WEST SUSSEX COUNTY COUNCIL CONSULTATION

TO:	Arun District Council FAO: Andrew Wood
FROM:	WSCC - Highways Authority
DATE:	12 March 2020
LOCATION:	Eastlands Littlehampton Road Worthing BN12 6PB
SUBJECT:	FG/8/20/PL Erection of 1 No. equestrian dwelling & retention of 1 No. gazebo & 2 No. carports. This application is a Departure from the Development Plan & may affect a Public Right of Way.
DATE OF SITE VISIT:	n/a
RECOMMENDATION:	Advice
S106 CONTRIBUTION TOTAL:	n/a

Title:
Proposed Site Plan

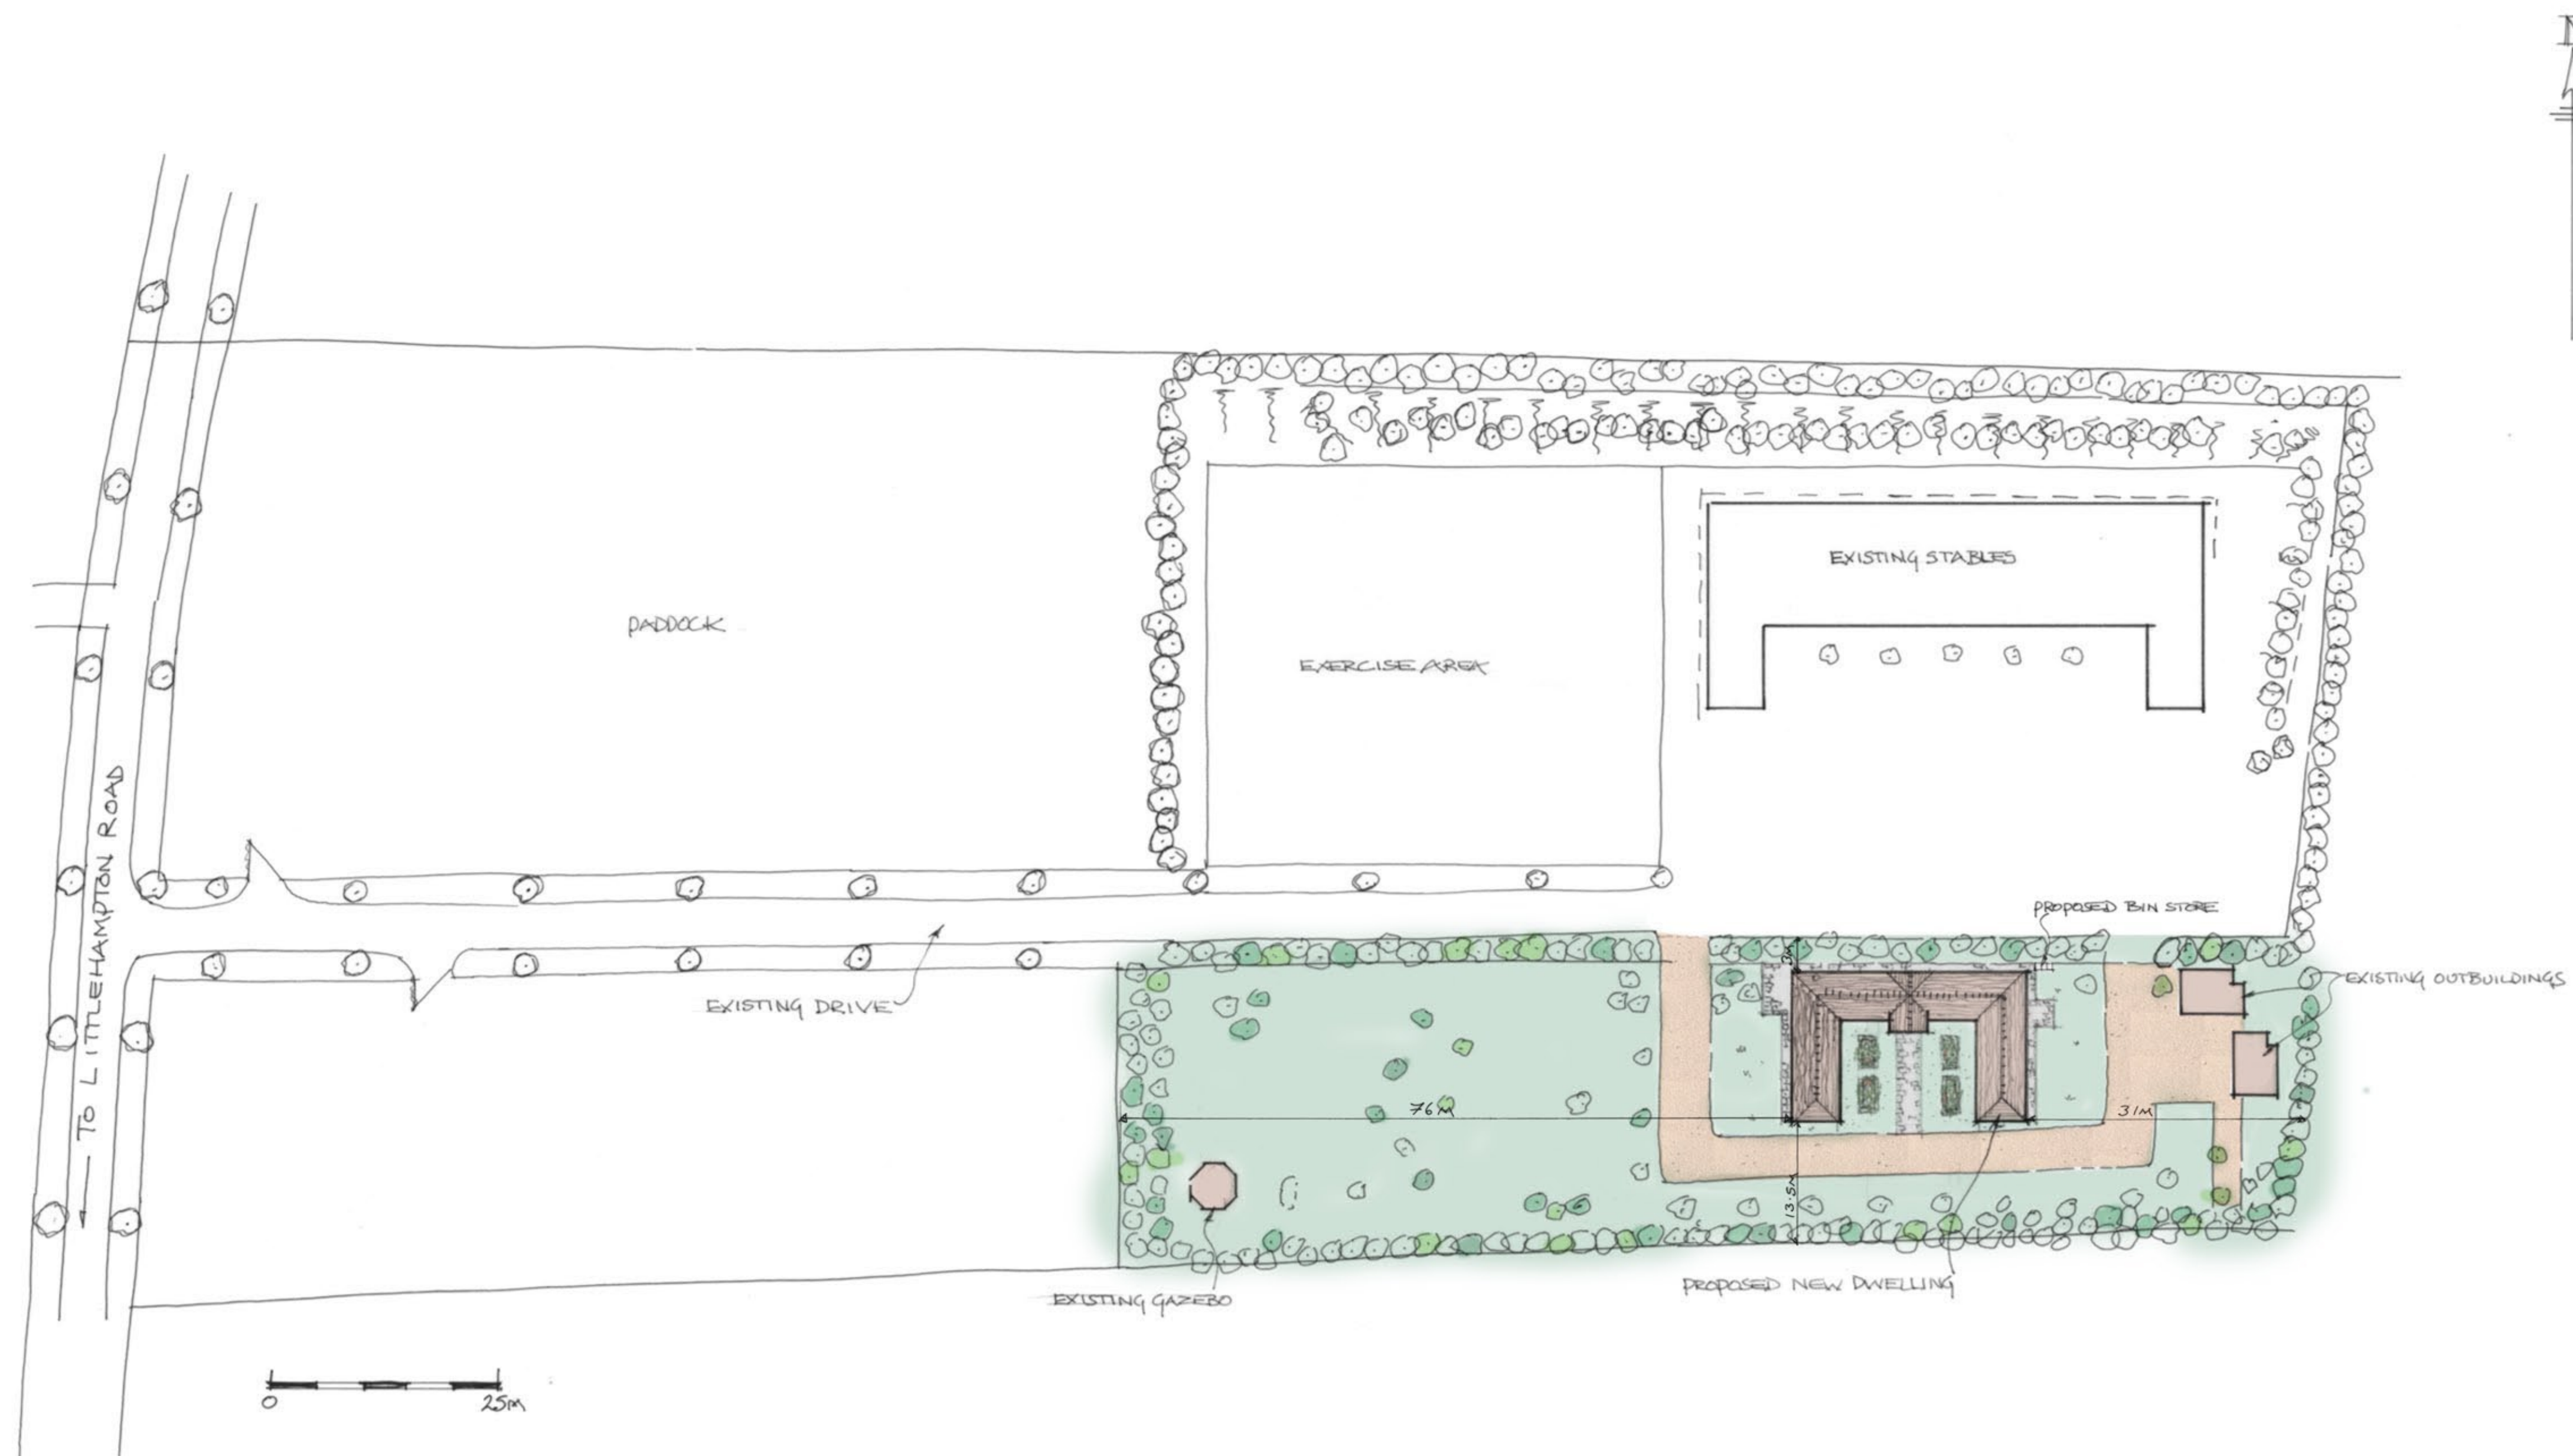
The applicant has not demonstrated a turn on site. The proposed hardstanding area is large enough to accommodate such a provision. This conforms to Manual for Streets (MfS) Guidance of a minimum of 6 metres to the rear of any parking space.

PARKING PLAN SD/1

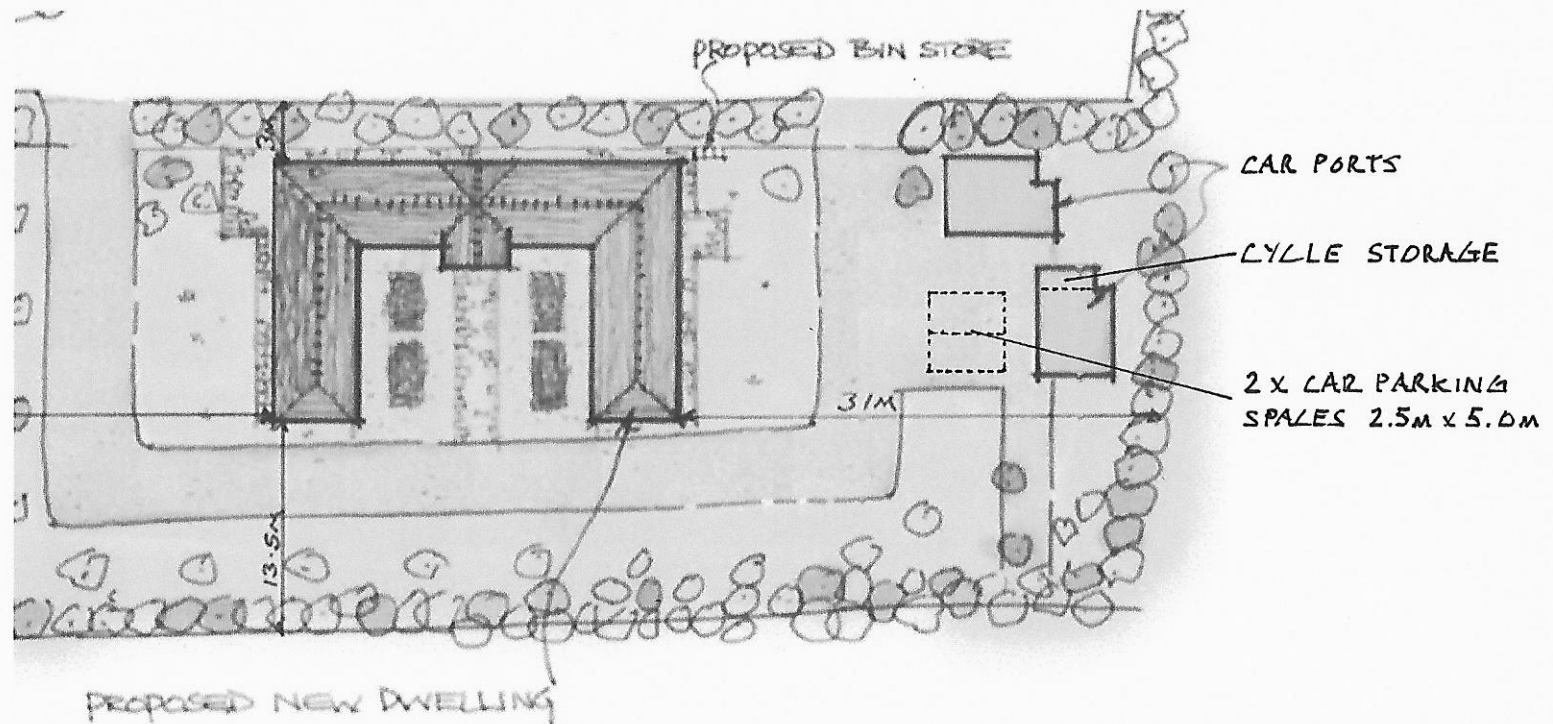
The applicant has demonstrated,

- (2x) 2.5 x 5 metre parking spaces,
- One carport measuring 5 x 5 metres,
- One carport measuring 3 x 5 metres.

These areas would equate to five parking spaces, the LHA notes that the hardstanding area appears to be large enough to accommodate more if needed.

The applicant proposes that cycle parking will be located within enclosed section of the car port. This conforms to requirements set out by Manual for Streets (MfS) and WSSC guidance for covered, lockable storage.
